Householder Proforma

Application Ref:	2020/1065
Address:	Huthwaite Snug Cottage, Huthwaite Lane, Thurgoland, Sheffield S35 7AF
Neighbour Representations:	Yes – one letter of support
Consultations:	Parish Council – No objections
Property Description:	
Proposed Extension:	erection of a single storey front extension
UDP Designation:	Green Belt
Local Plan Designation:	Green Belt
Conservation Area:	No
Relevant History:	N/A
Acceptable in Principle:	Yes

20/09/64. Ref.
West Elevation proposed Extension
1/20 scale.

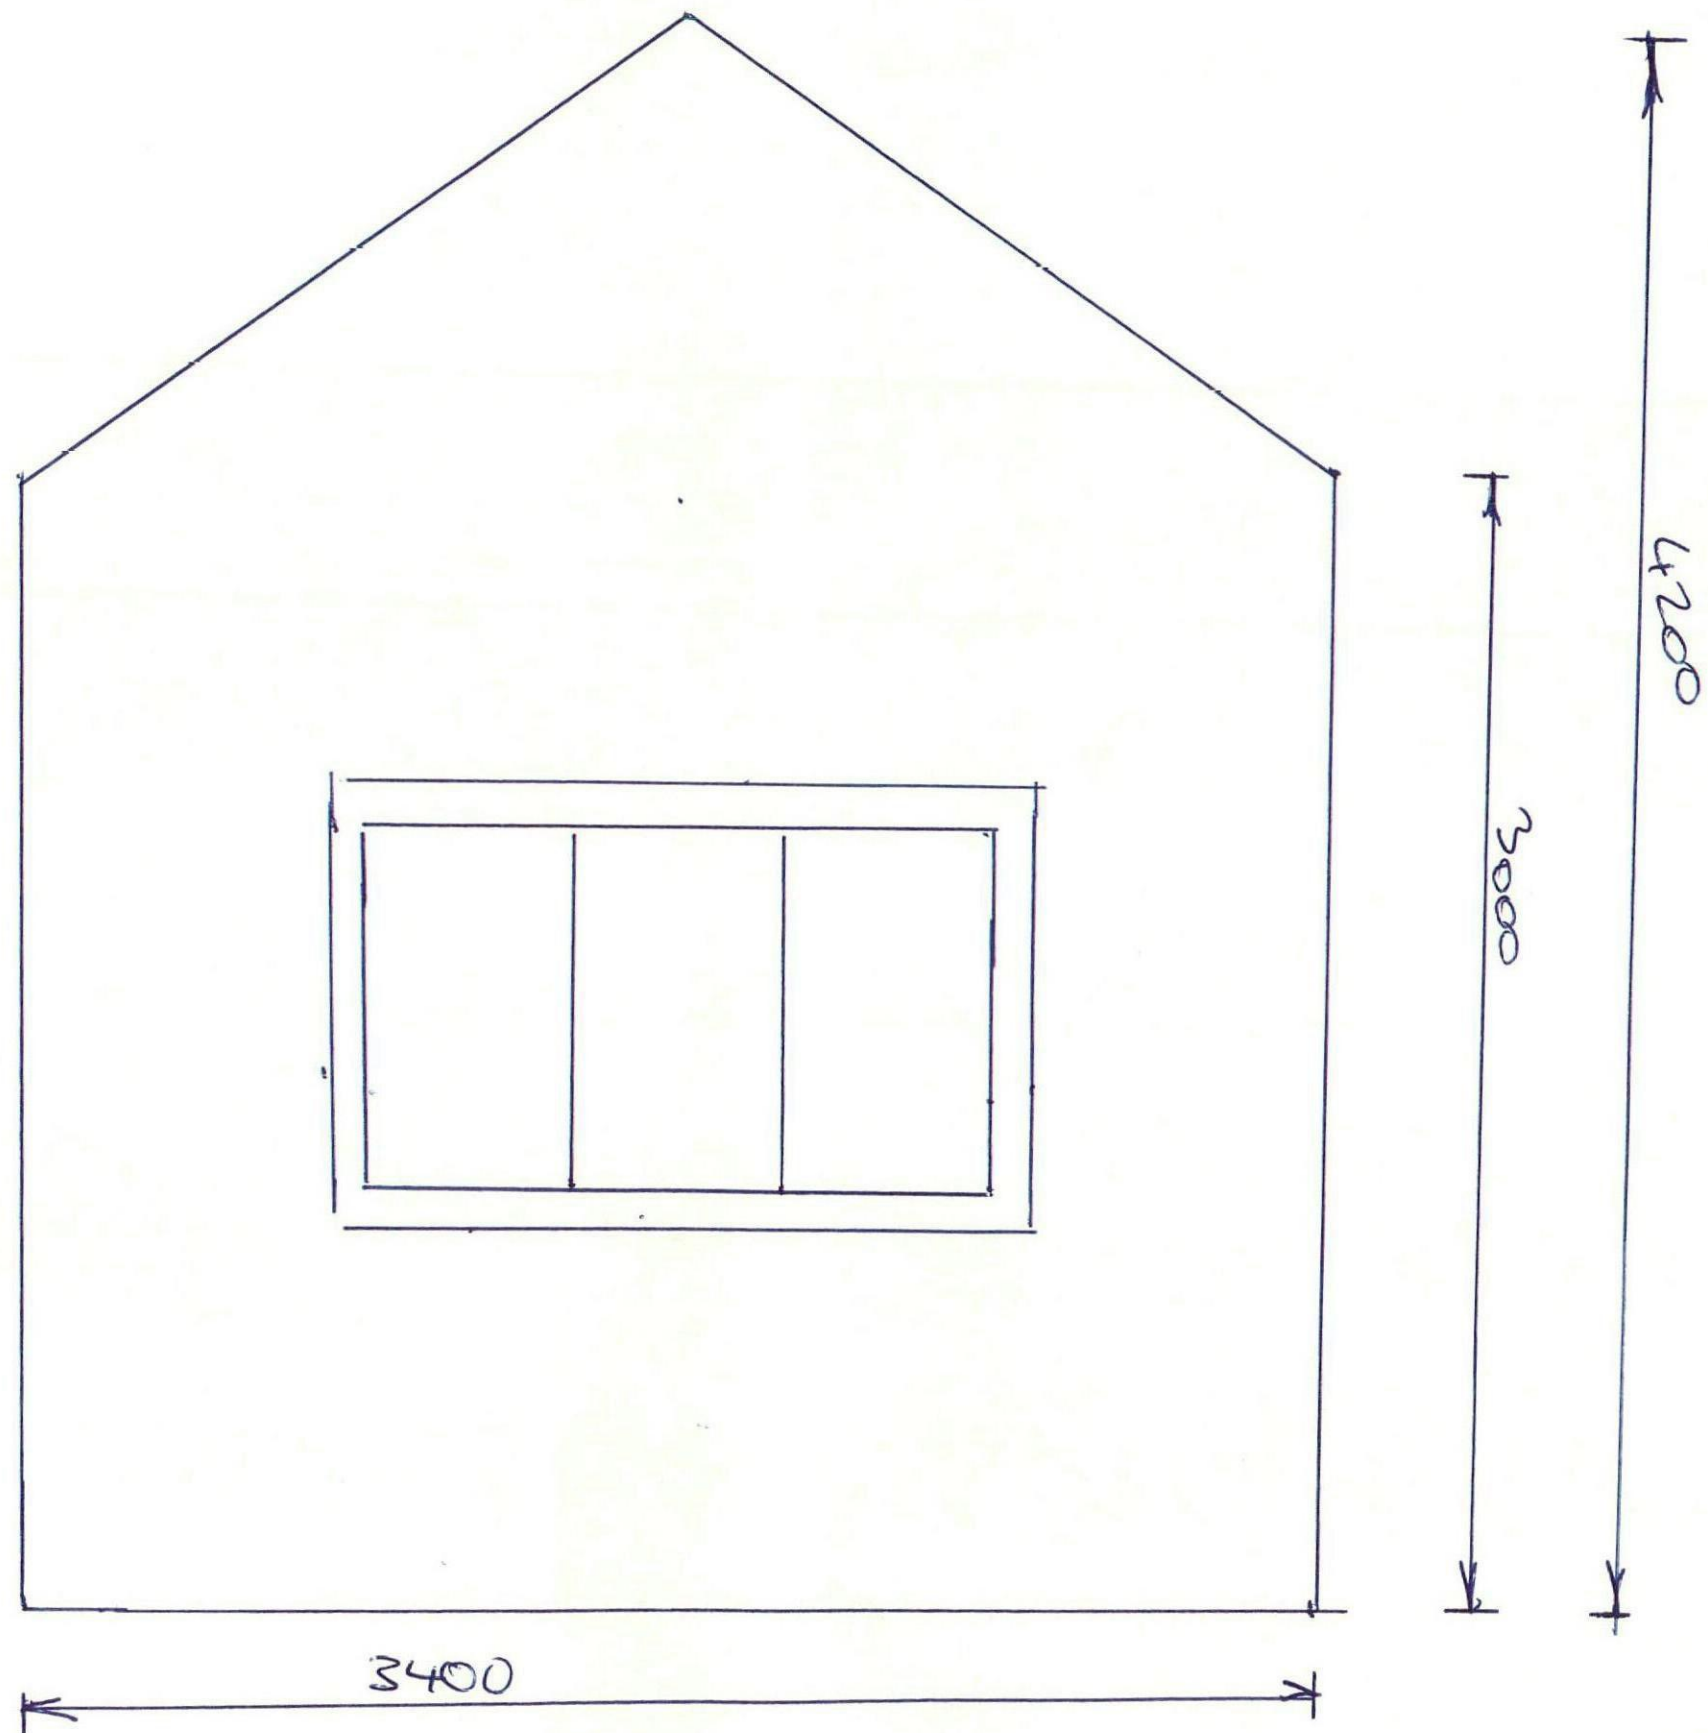
The windows on the proposed extension are to be located on the front and western side elevations and not on the eastern side elevation facing the adjoining property which would therefore not increase levels of overlooking.

Proposed extension

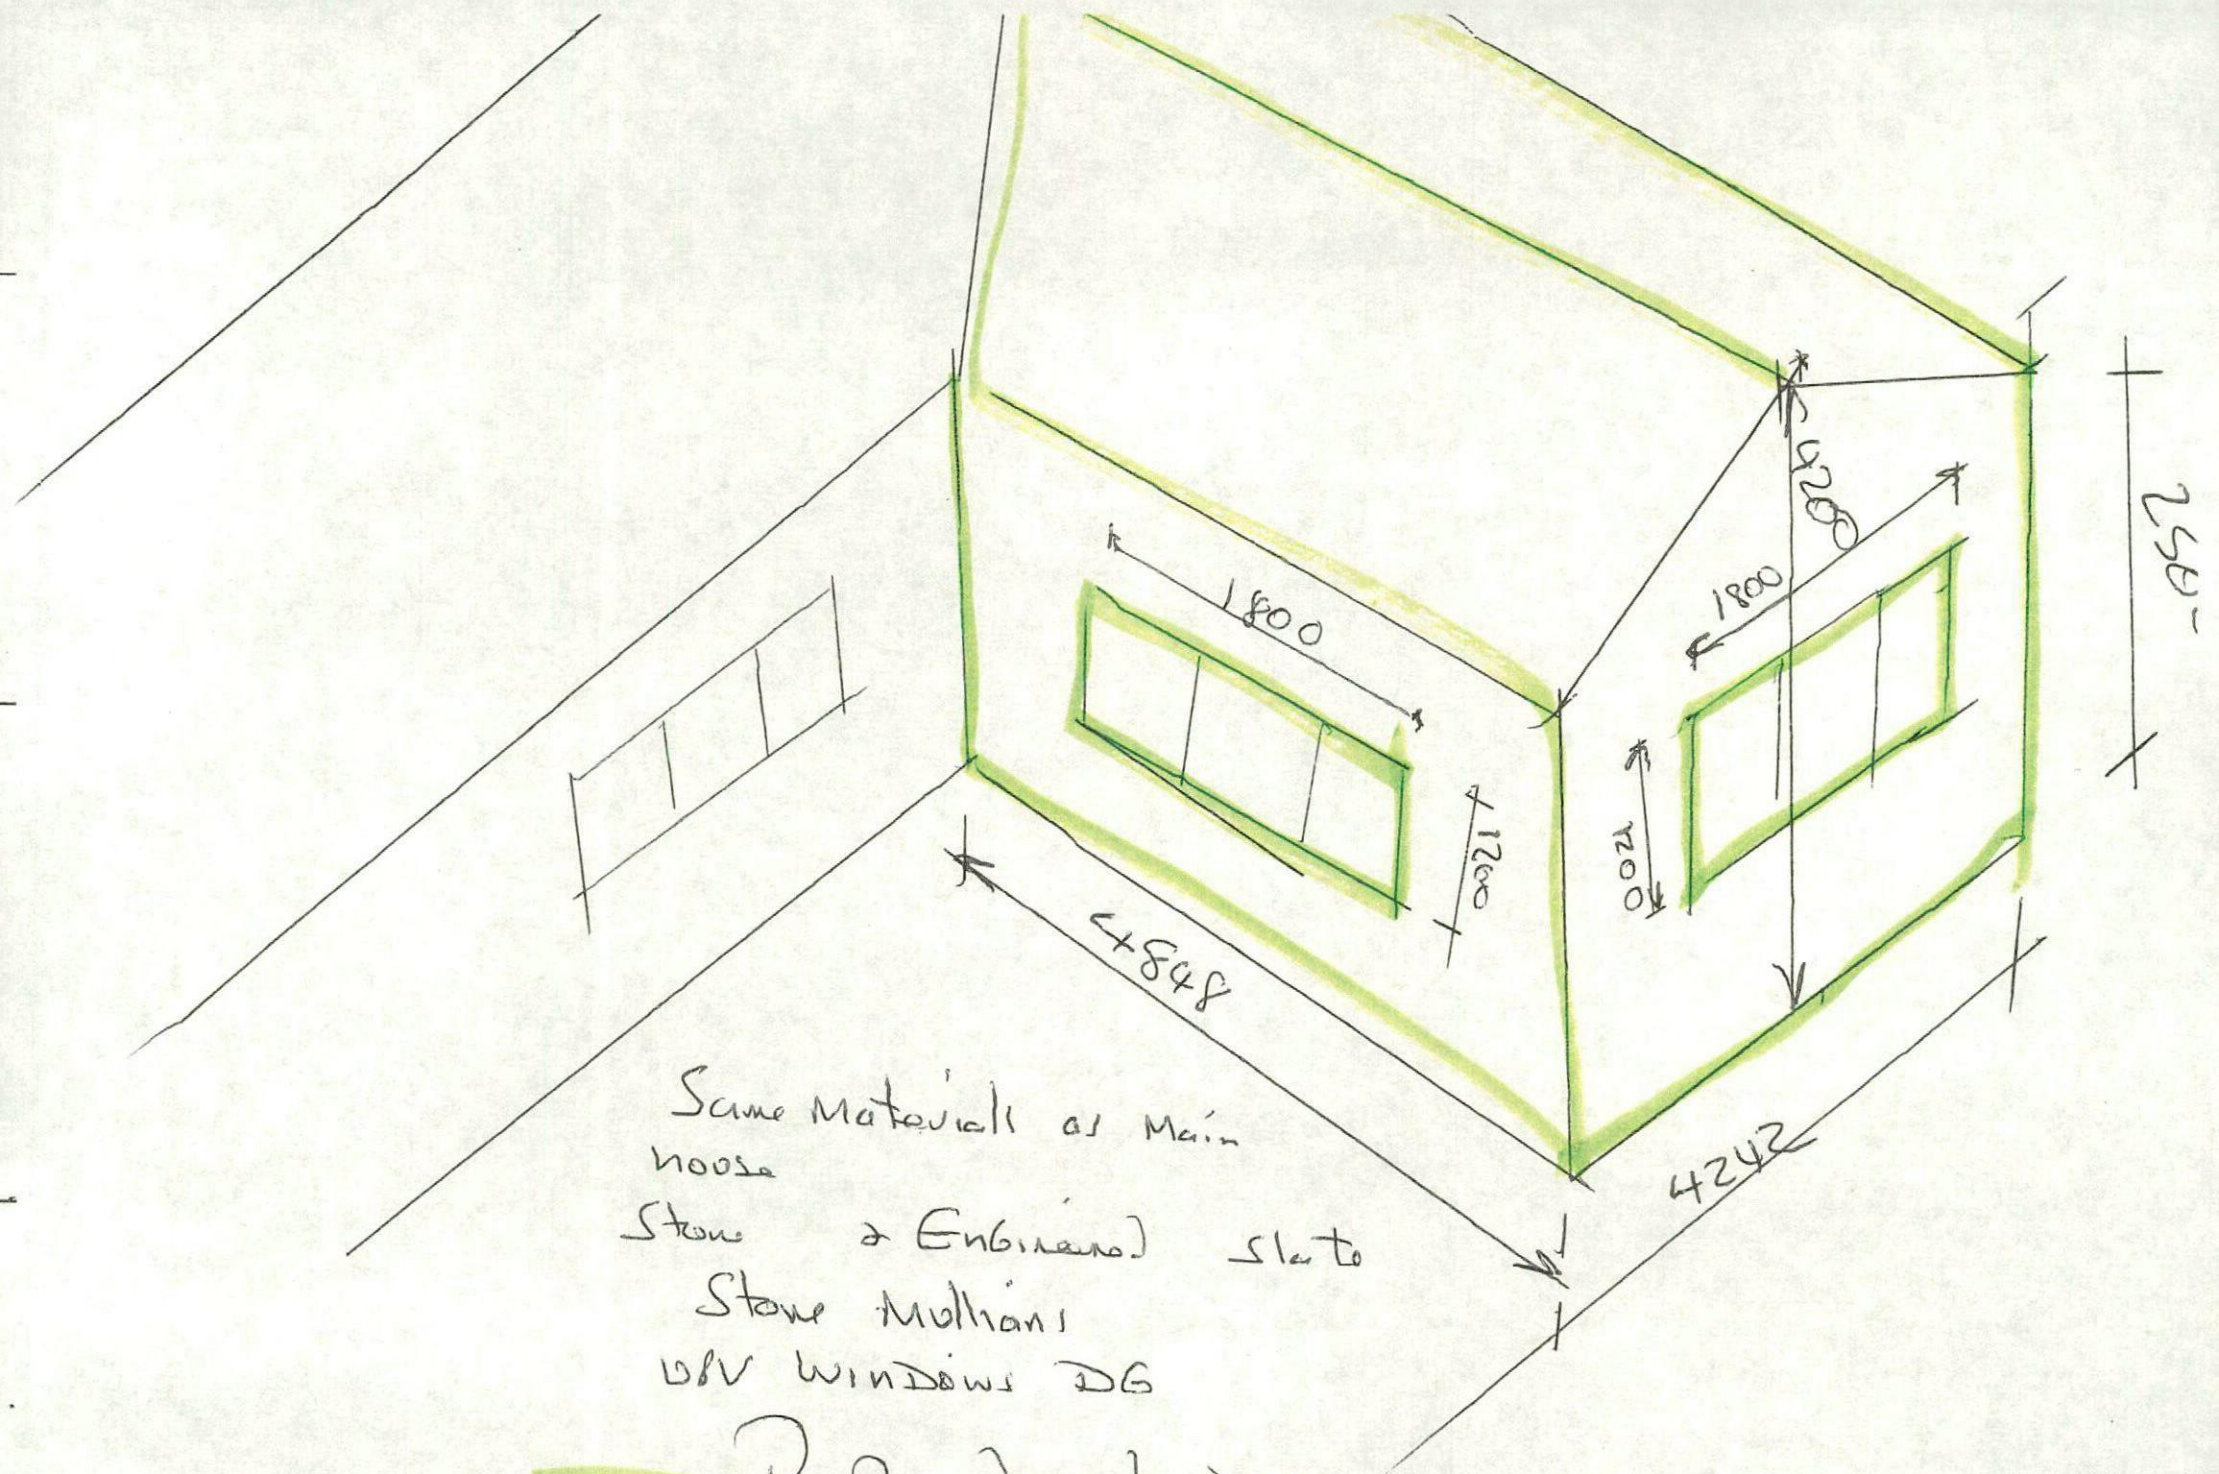
The applicant seeks permission for the erection of a single storey front extension to the dwelling. The extension is to project 4.8m from the front elevation extending 4.2m along it. It is to be located adjacent to the party boundary with the adjoining property, which could lead to an increase in overshadowing and loss of outlook, however the extension, is to be located adjacent to an existing privet hedge which is to be retained, it is therefore considered that the inclusion of the front extension would not have a significant detrimental impact on the adjoining property.
